**Application No:** 19/00213/DISC

**Proposal :** Discharge of conditions 6 (new link road), 8 (surface water drainage), 9 (floor levels), 10 (play areas), 11 (arboricultural survey), 12 (ecology), 13 (secured by design), 14 (contamination), 18 (mitigation for badgers) and 35 (cycle lanes) of 15/01326/OUT

**Location:** OS Parcels 6741 And 5426 West Of Cricket Field Nor, Wykham Lane, Bodicote

Condition 8 Not Discharged

Swale 1

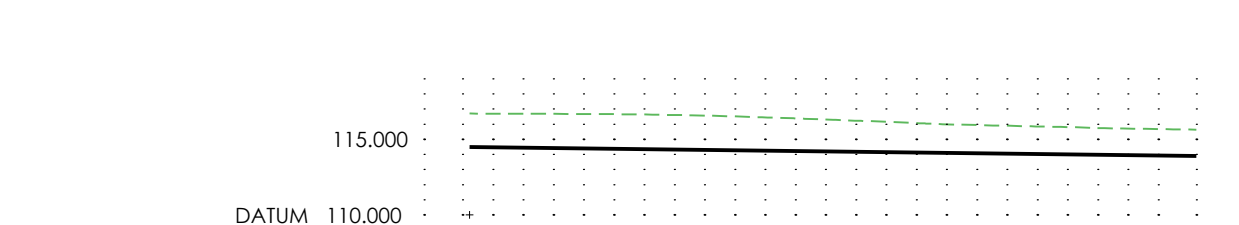
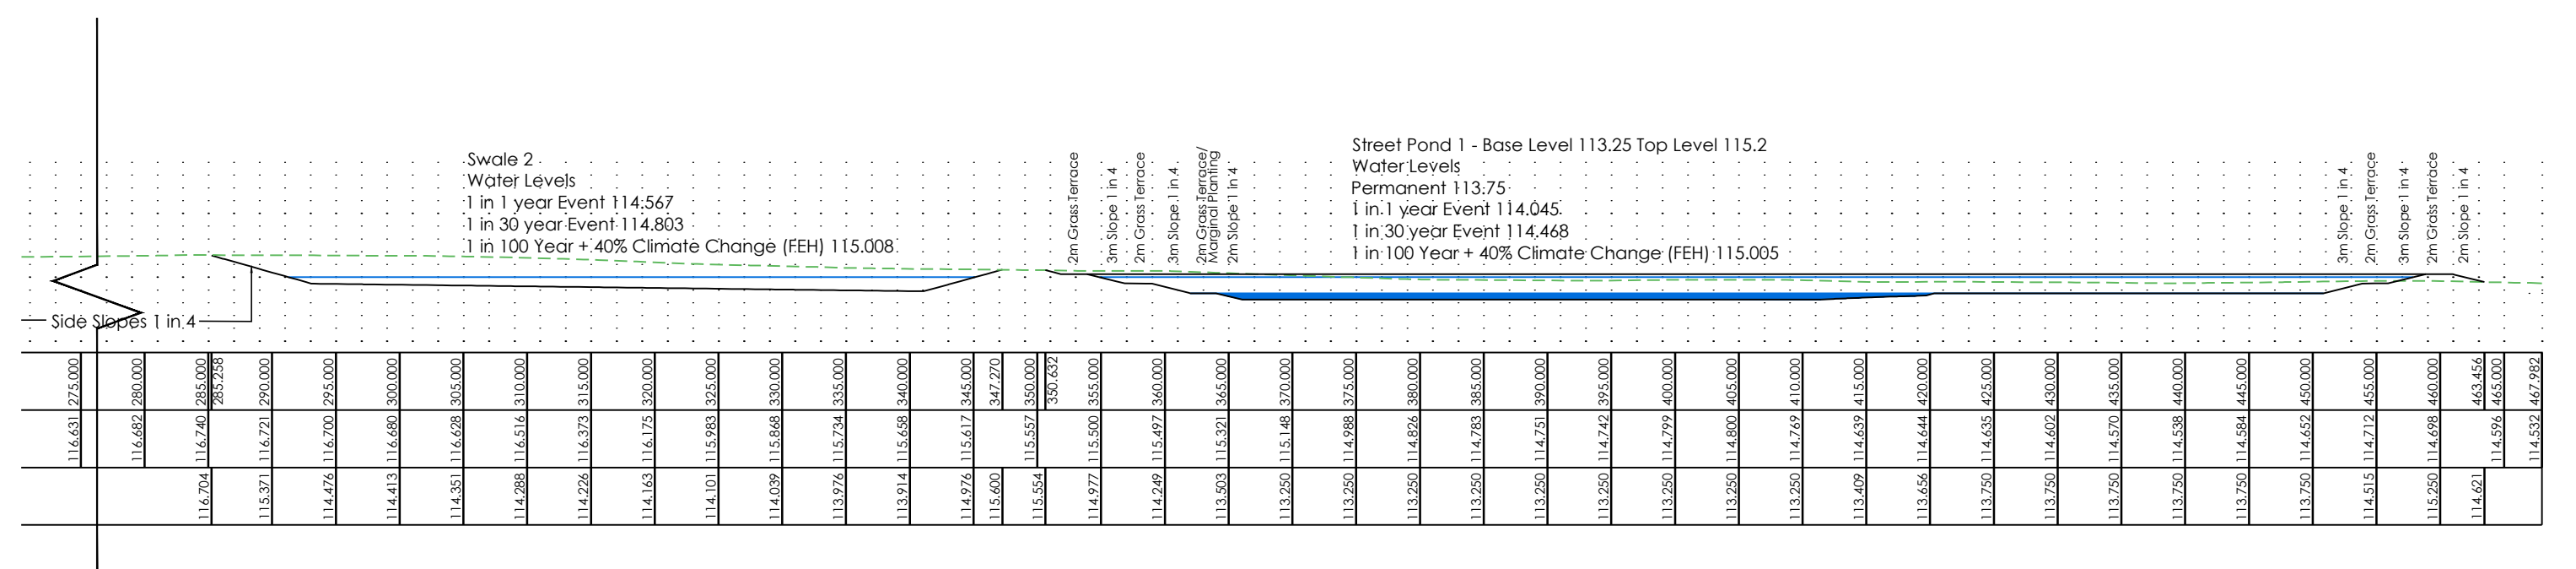
The calcs for the cellular soakways, filter trenches and the private swales look OK  
However, no calcs have been provided for SuDS ponds 3,4,5&6.

These are in the network calcs however we need a detailed section drawing through all the SuDS ponds or contours on the drawing to check top of bank levels against peak water levels in the calcs.

TITLE: **Adoptable Drainage**

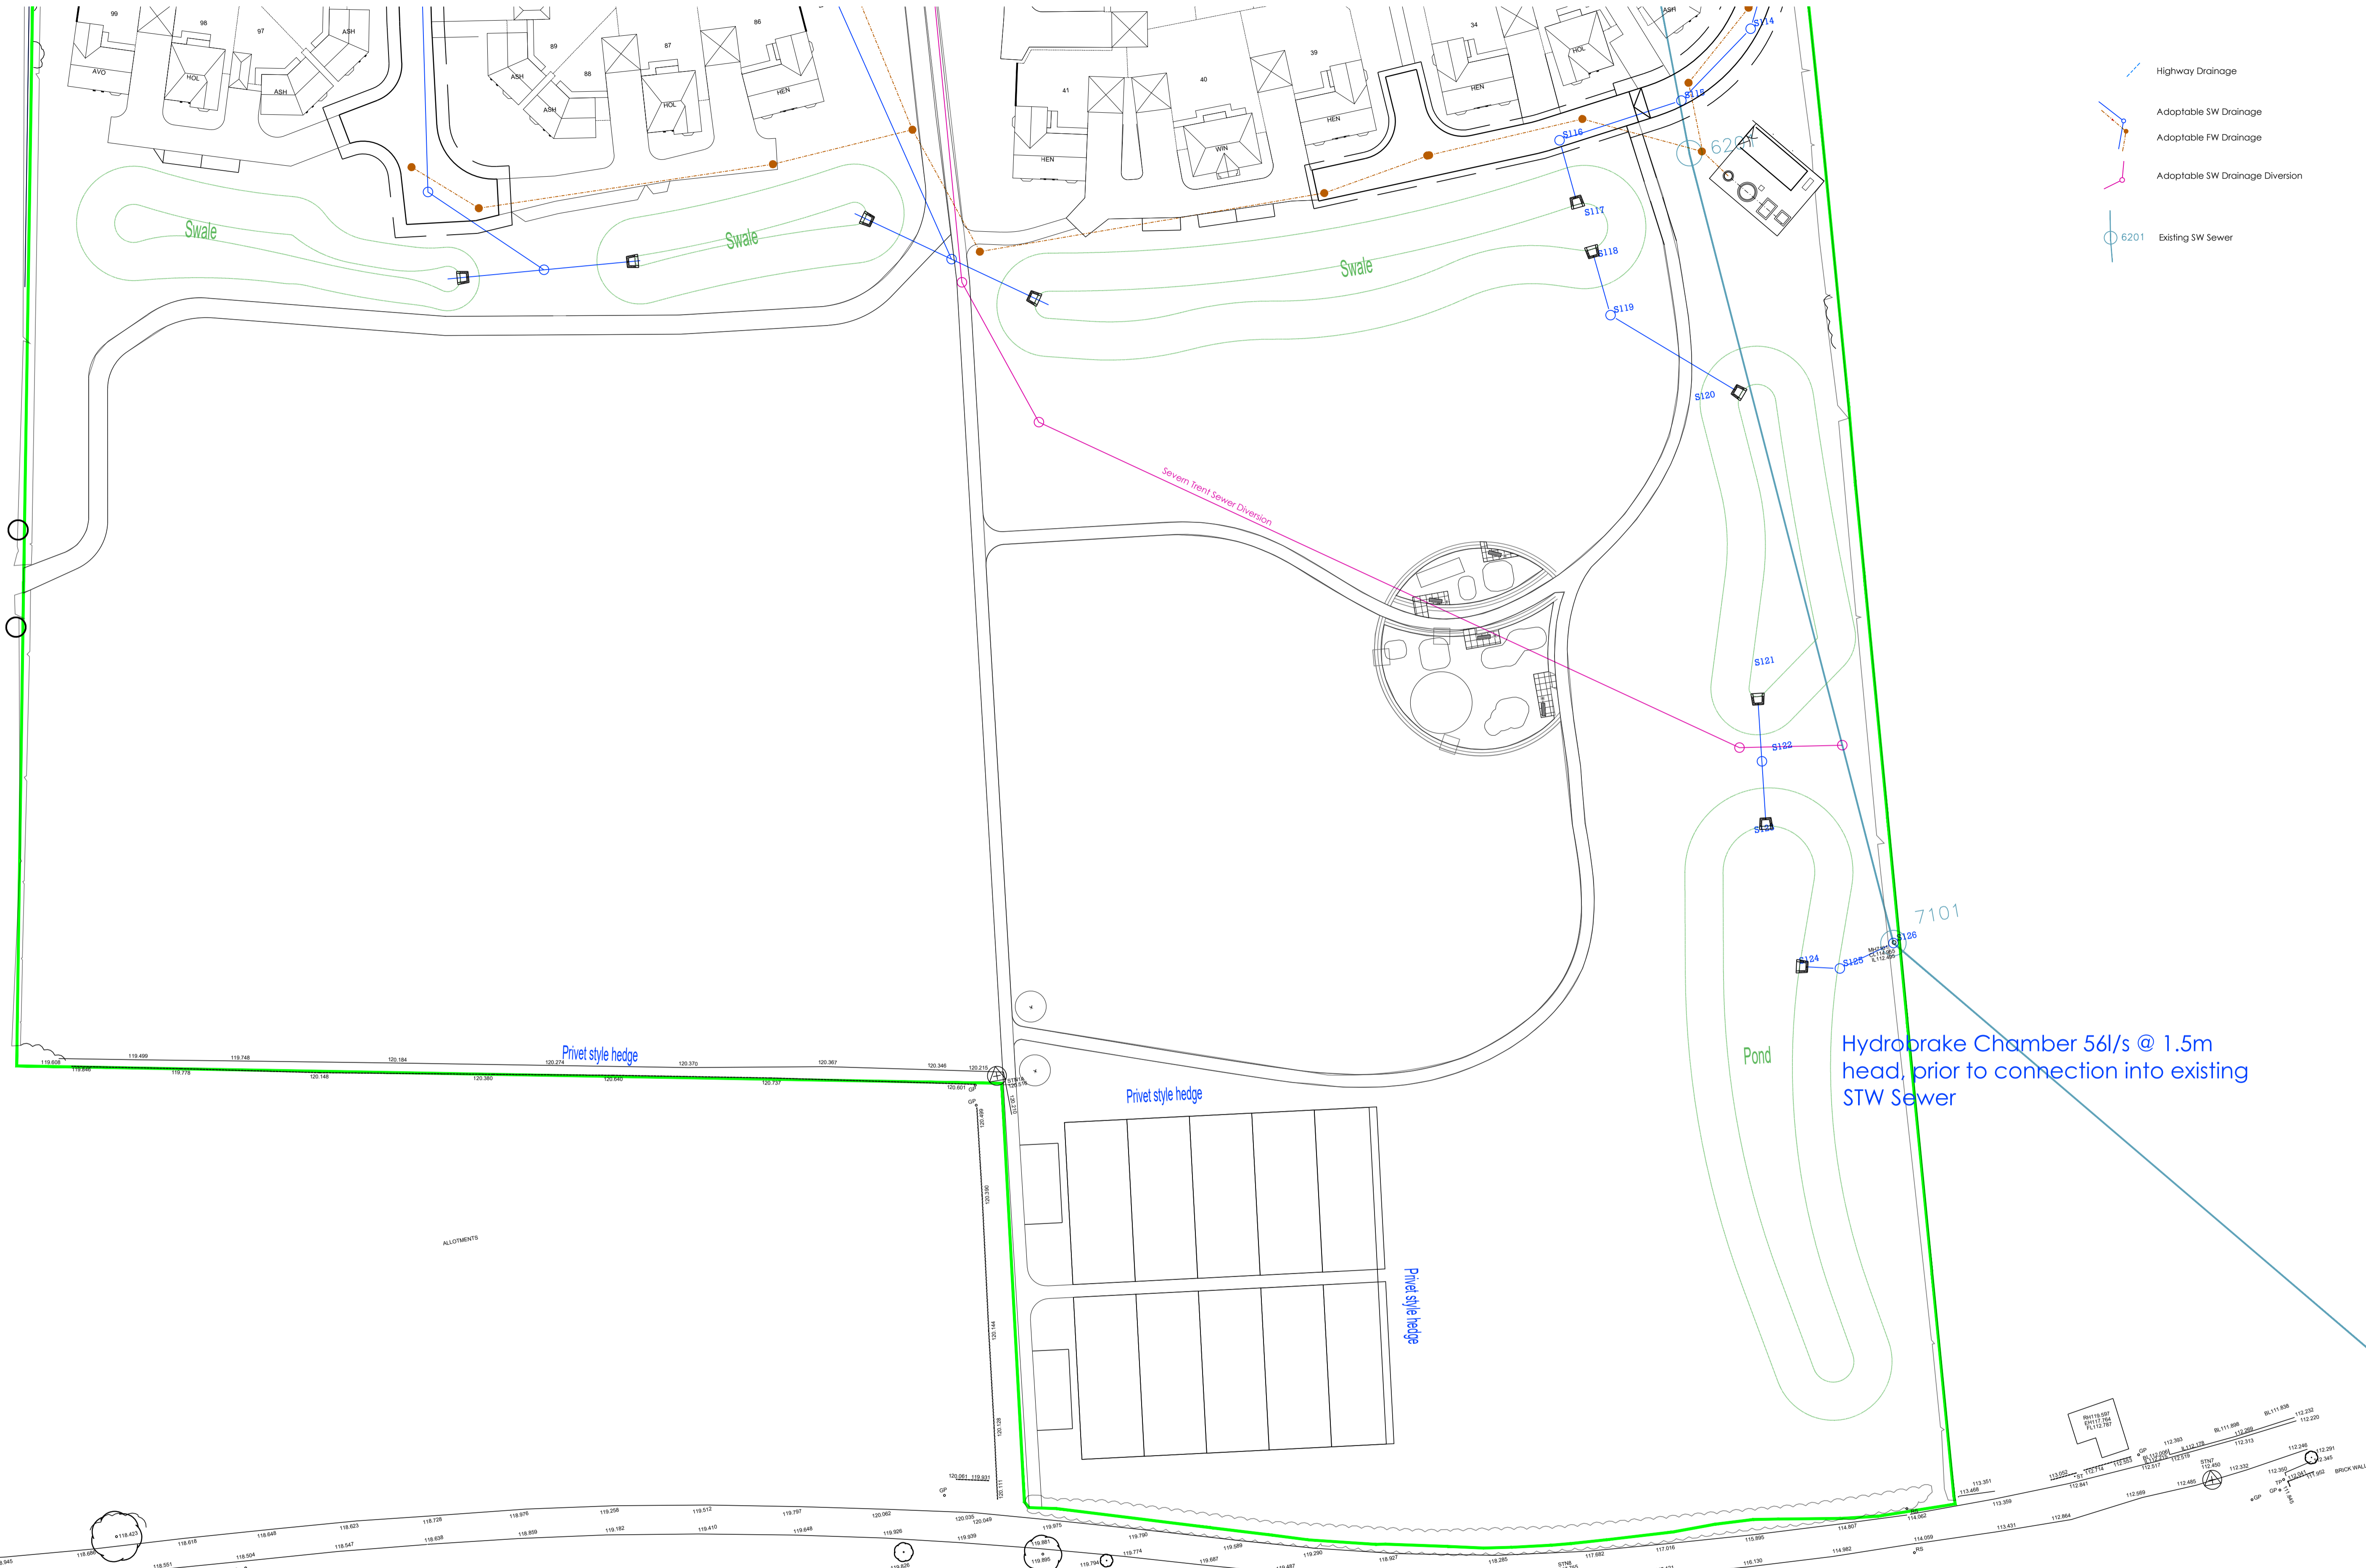
The proposed system is discharging at the following rates:

2y – 53.5 l/s

30y – 56.0 l/s

100y+40%cc – 56.0 l/s

This results in an increase in the peak rate of runoff over existing greenfield conditions. No consideration of the increase in runoff volume has been made. Inline

with local and national standards, flow rates must be restricted to  $Q_{bar}$  or a complex control used to ensure volume isn't increased from the development.
